Chatswood Chase Shopping Centre Table of Response to Submissions

The table below summarises the responds to issues raised as part of the exhibition of the EAR. The table should be read in conjunction with correspondence from WCC dated 8 August 2007 provided in Appendix A.

Scale 1:200

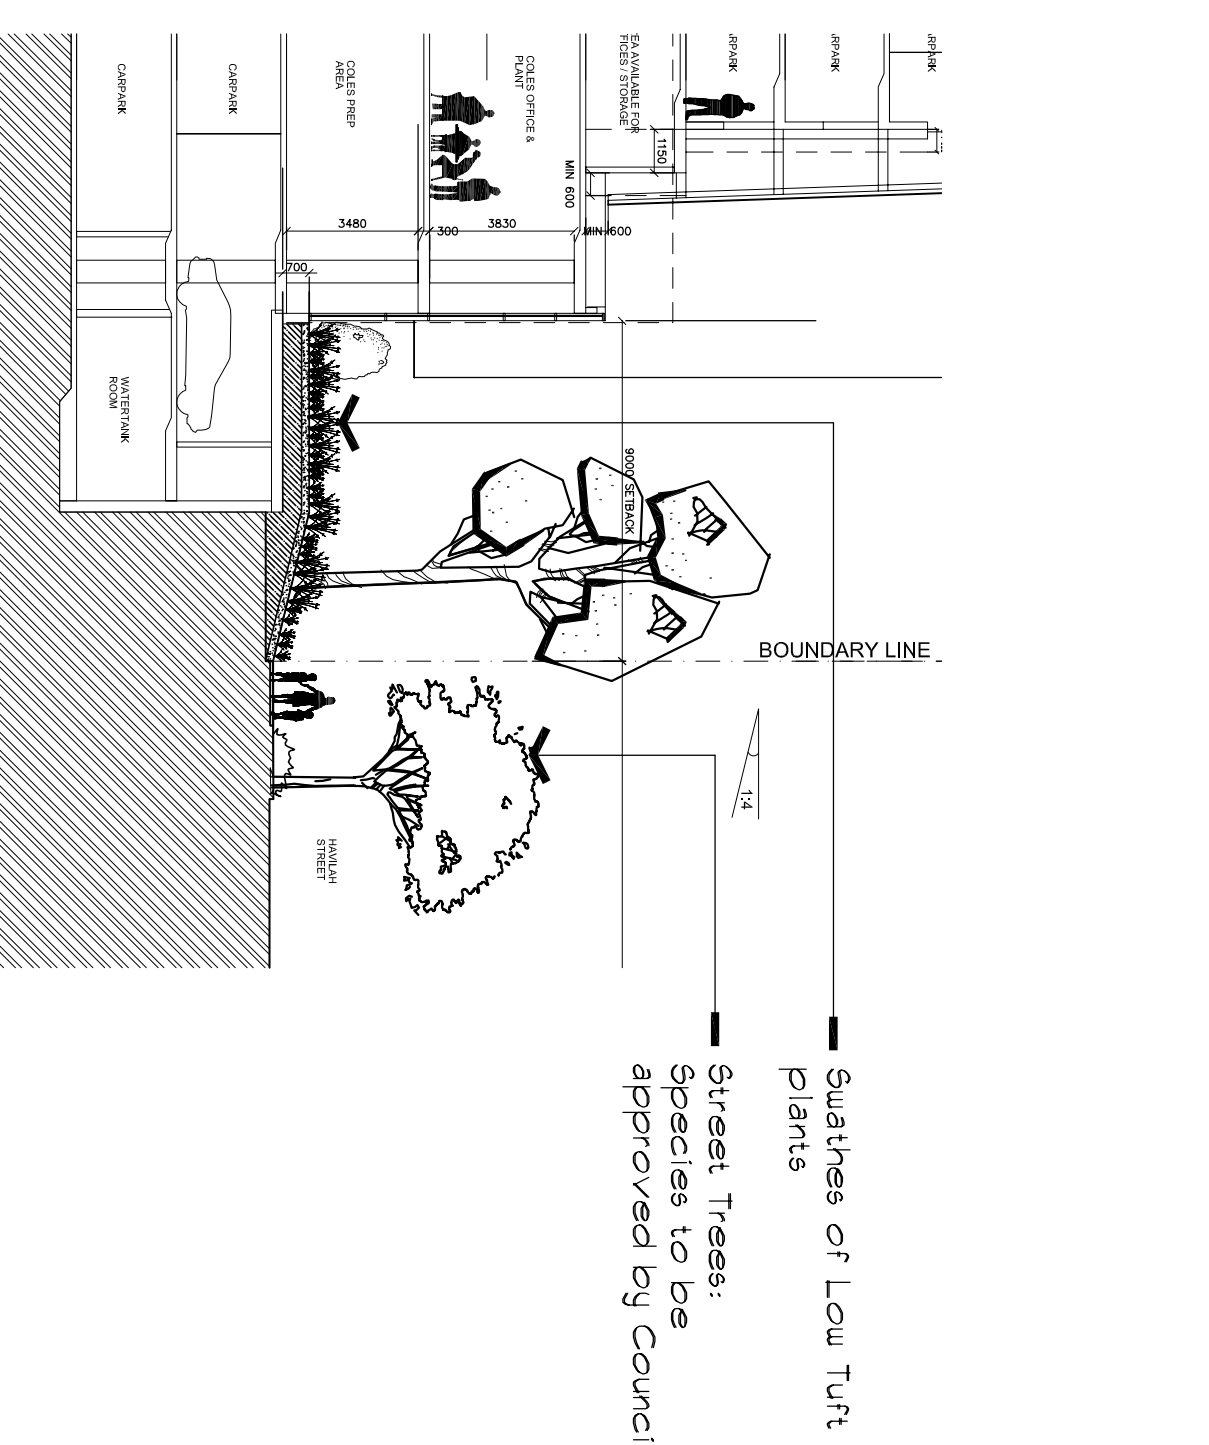
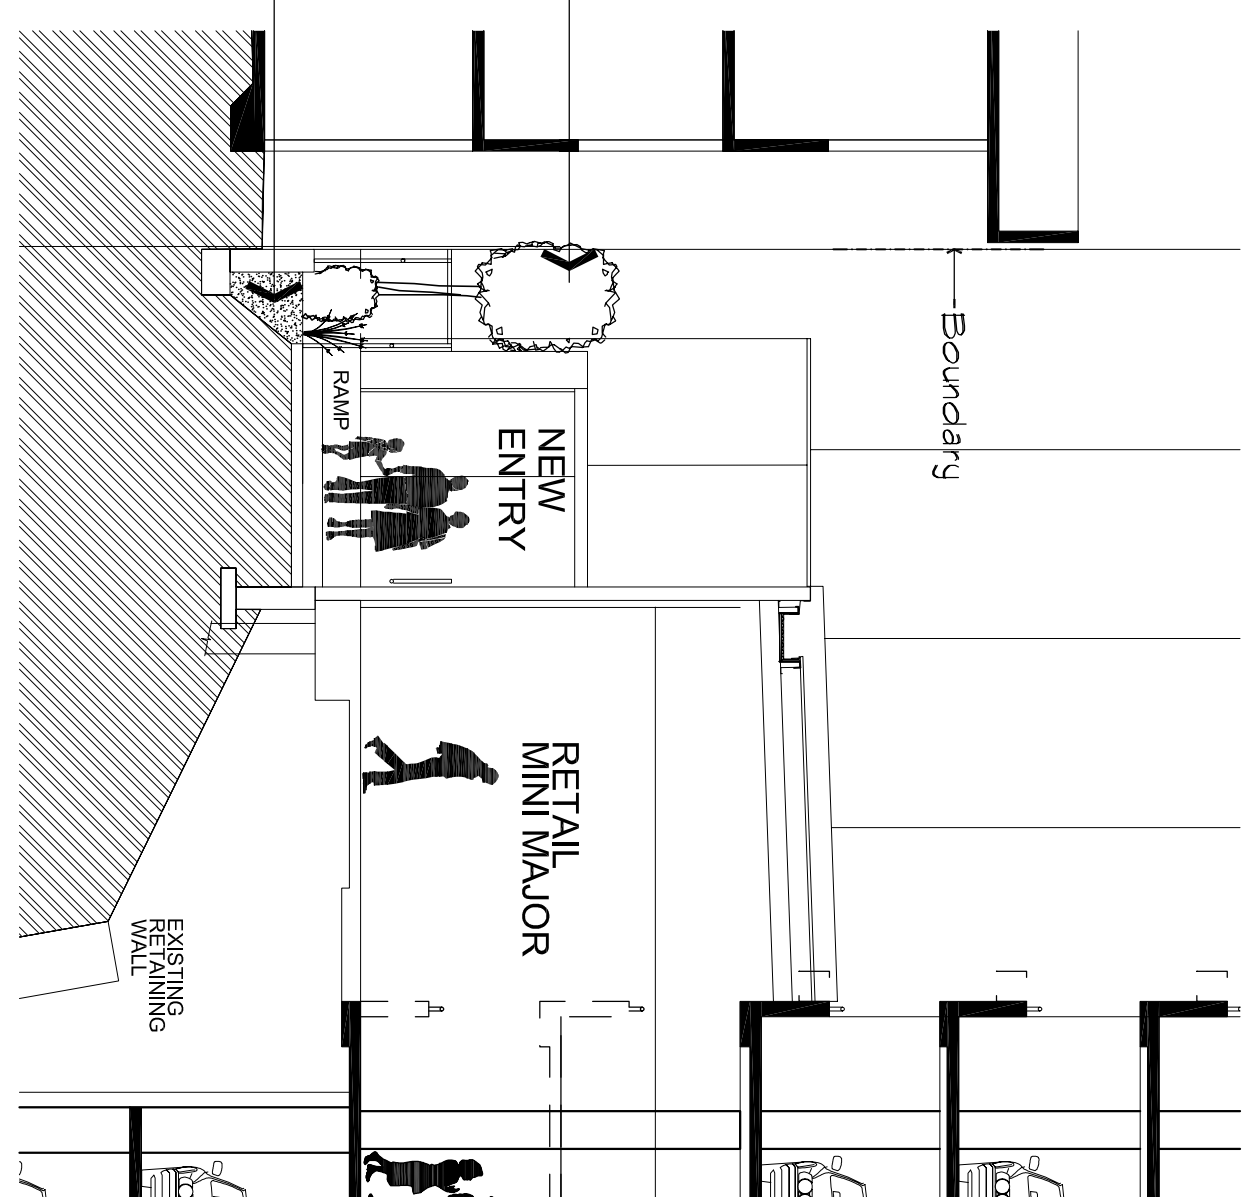
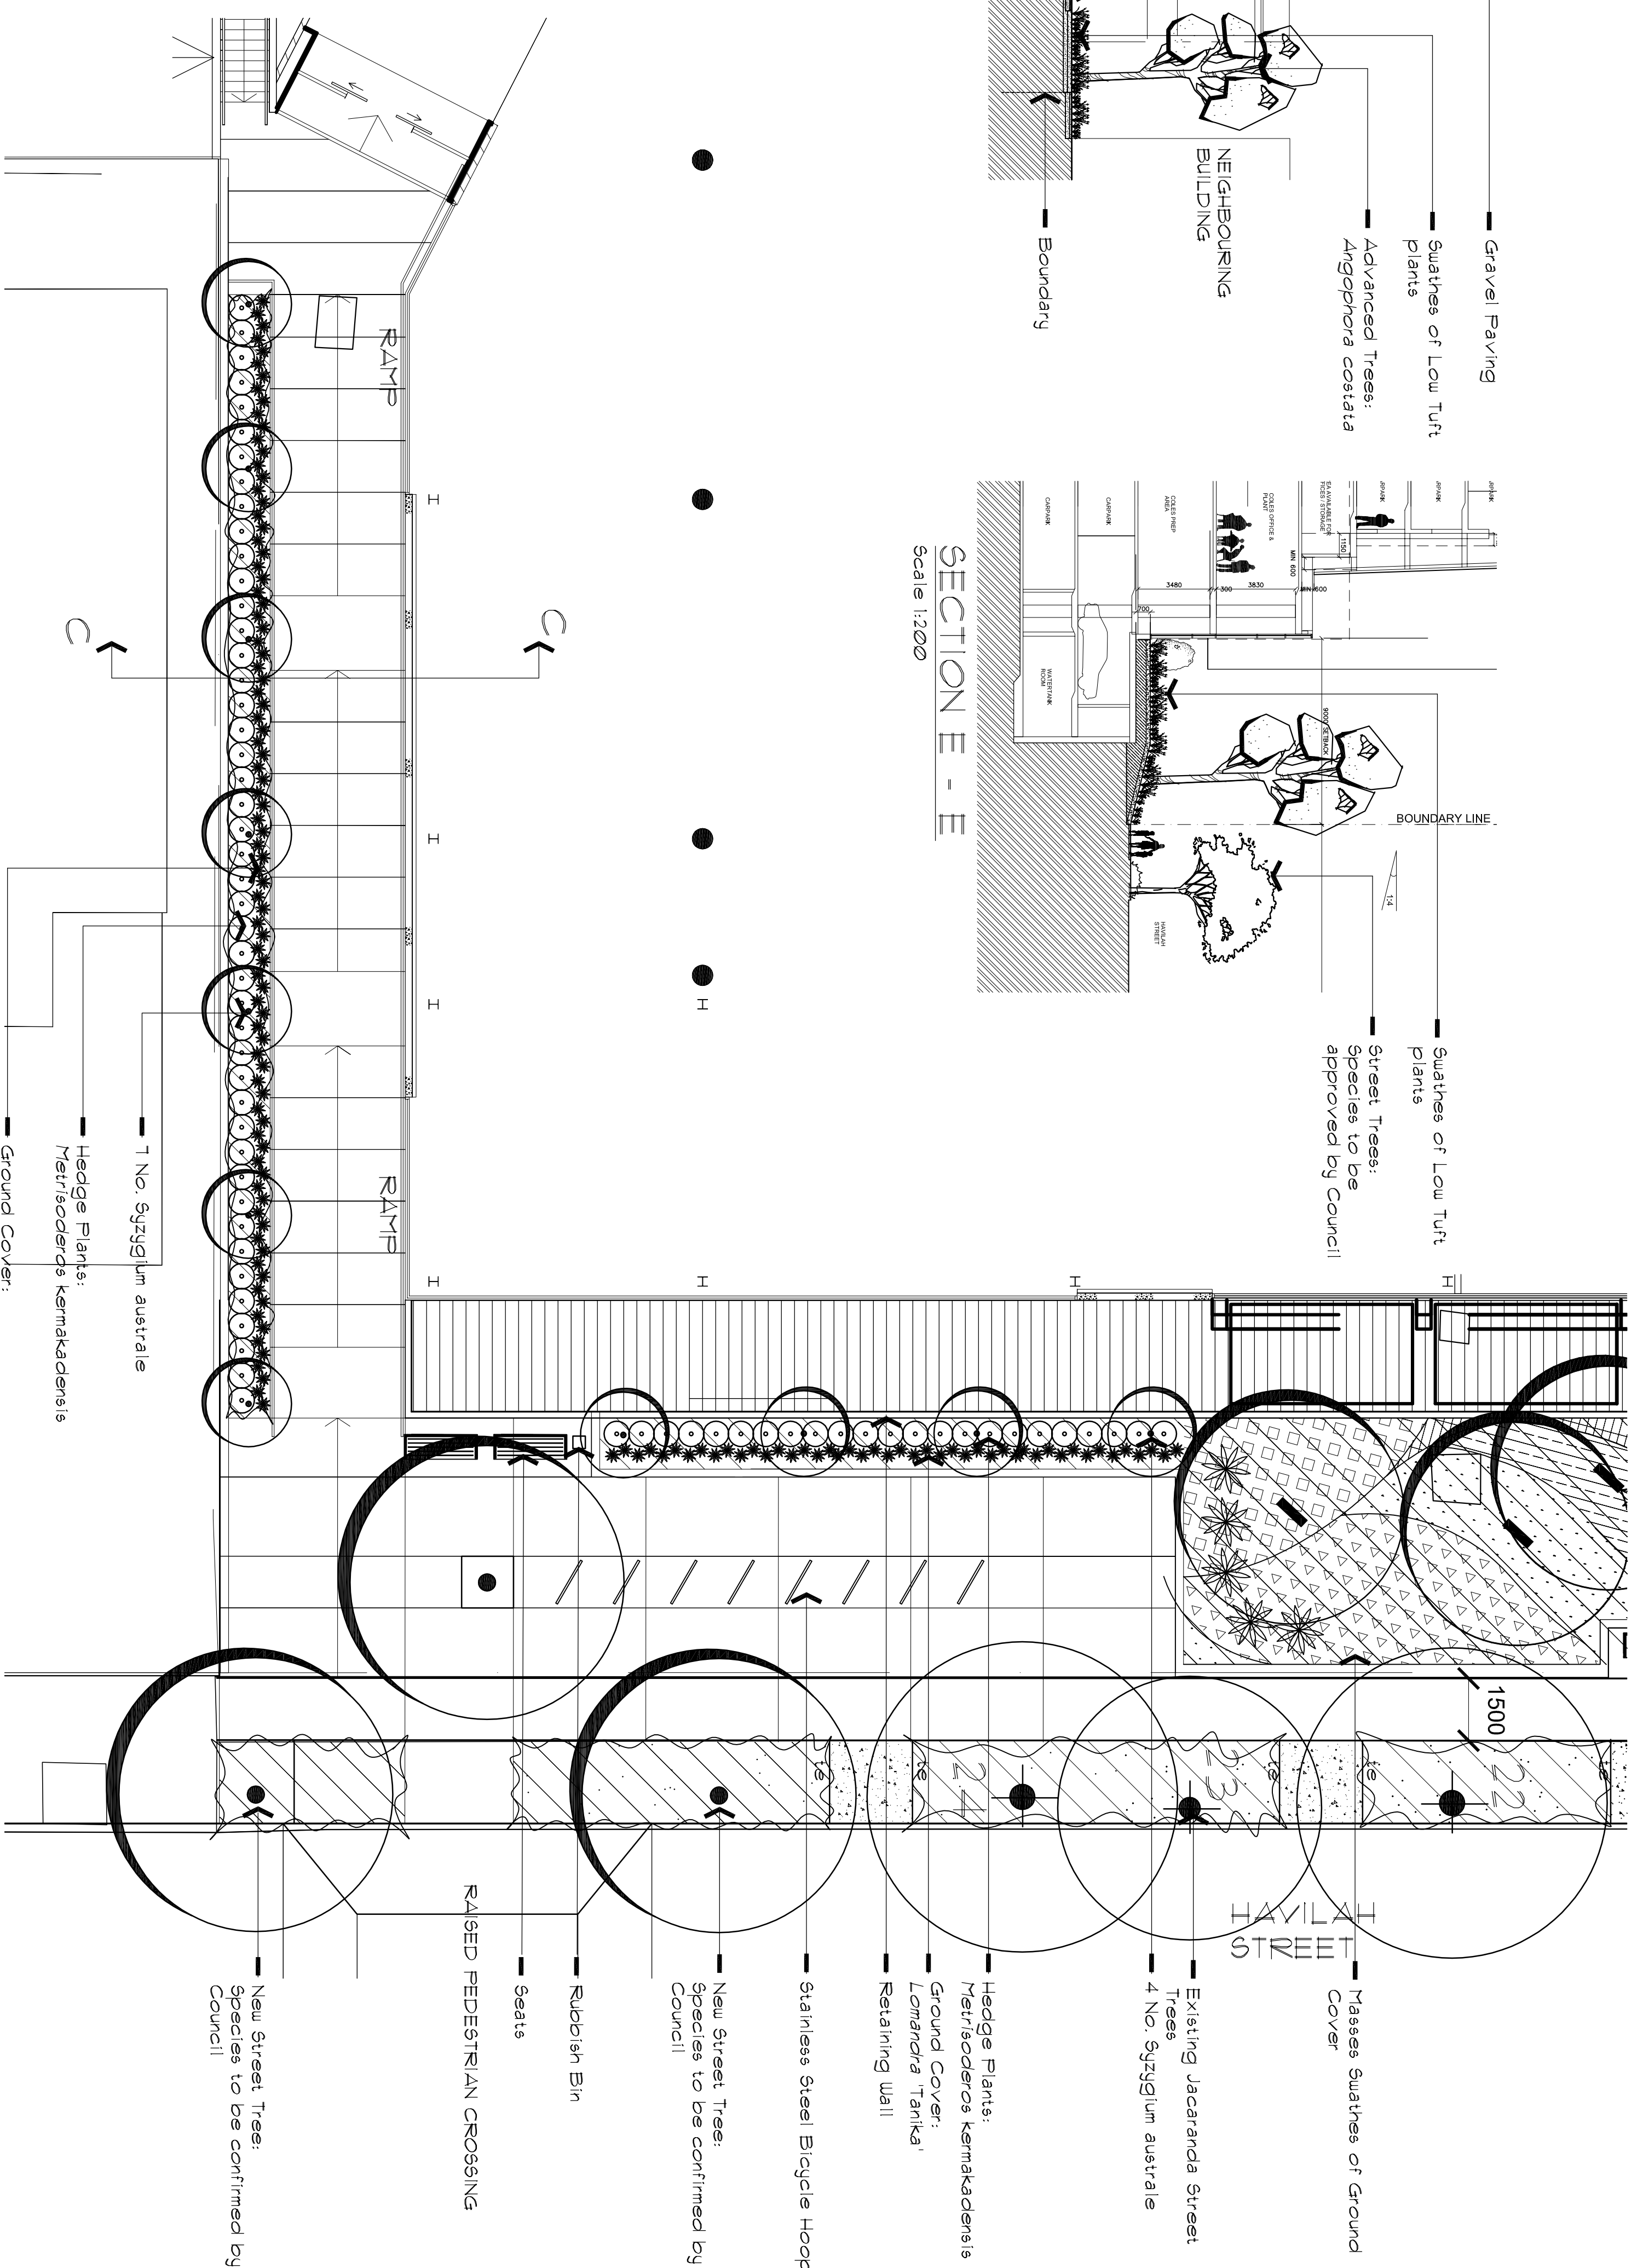
13	<p>At the public meeting, comment was made by your architect that it was expected that there was potential for three of the existing trees in the Havilah Street setback to the existing car park will be retained. Council's Landscape Section requires clarification on this point having regard to the extent of demolition and building works that may impact on the root system of the trees. The clarification needs to carefully consider the species, age and health of the trees noting that if damaged through the demolition/construction process, they may become a danger in the future for pedestrians in the vicinity.</p>	<p>The existing tree screen will be lost during construction. A new integrated landscape installation will be provided from 5-7 Havilah Street around to the boundary with 12-14 Malvern Avenue.</p> <p>Hedge planting and new street trees will be planted to Council requirements along Havilah Street as agreed with Council. Illustrated on updated Landscape Plans, Drawing Numbers 1461-LC1 and 1461-LC2.</p>

14a	<p>Various inconsistencies exist between the landscaped plan and the architectural plans, these require review and clarification. These include:</p>	Updated Landscape Plans provided, Drawing Numbers 1461-LC1 and 1461-LC2.
14b	<p>– Level changes and the need for retaining walls along the boundary with Havilah Street in the architectural plans that do not appear in the landscape plans. Council's expectation is that the interface is seamless with minimal level change and if a change in level is required it is not of a height that requires fencing.</p>	The detailed design to achieve Council's expectation will be addressed prior to issue of the CC for Landscaping.
14c	<p>– A paved pathway from Malvern Avenue enters that site to the building but its purpose is unknown.</p>	Stepping stone pavers have been provided where access is required to switchrooms.
